DOC21/133262

Senders ref: SSD 10473 (North Sydney)

**Subject: Notice of Exhibition – Marist Catholic College North Shore, 270 Miller Street, North Sydney (SSD10473)**

**Figure 28 |** Existing (left) and predicted (right) flood conditions during the 1% AEP flood event (Source: Applicant's RtS 2022)

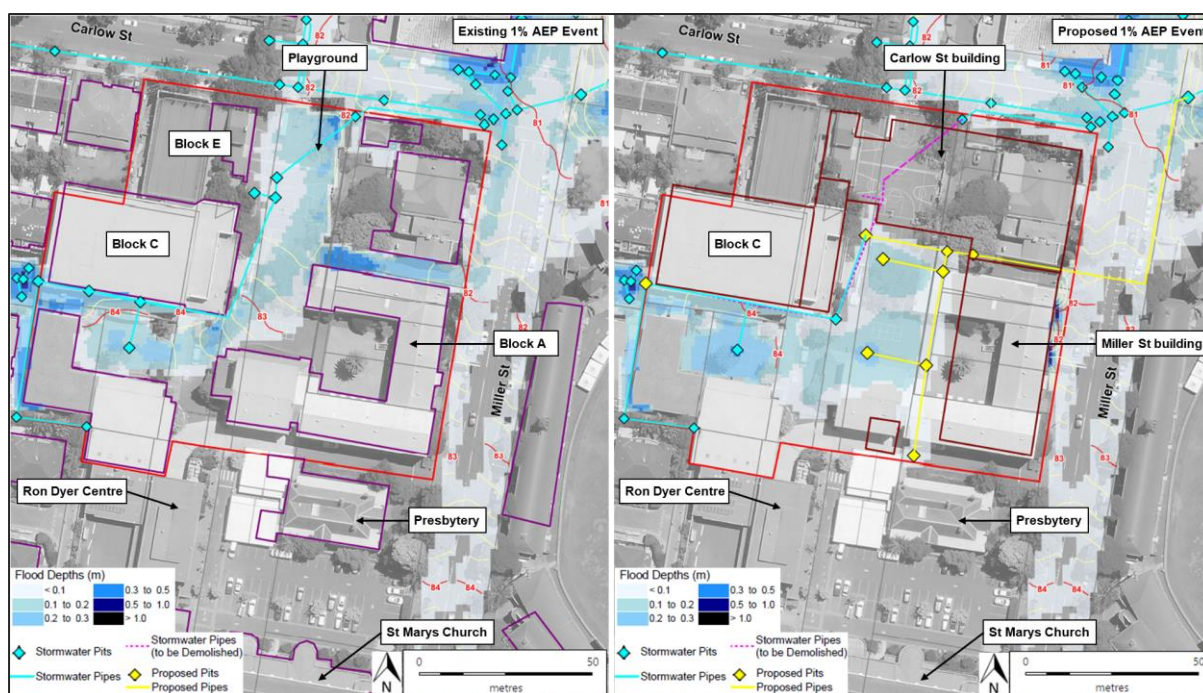
- The flood impact assessment determines that the proposed development will worsen flood affectation within the school site in the 1% AEP as shown in Figure 3. This impact must be addressed and mitigated.

- Mapping is limited to 1% AEP Flood depth. There are no maps to show the impacts of the development on flood hazard in the 1% AEP. This information is required to guide decisions on the proposed works and on any mitigation options.
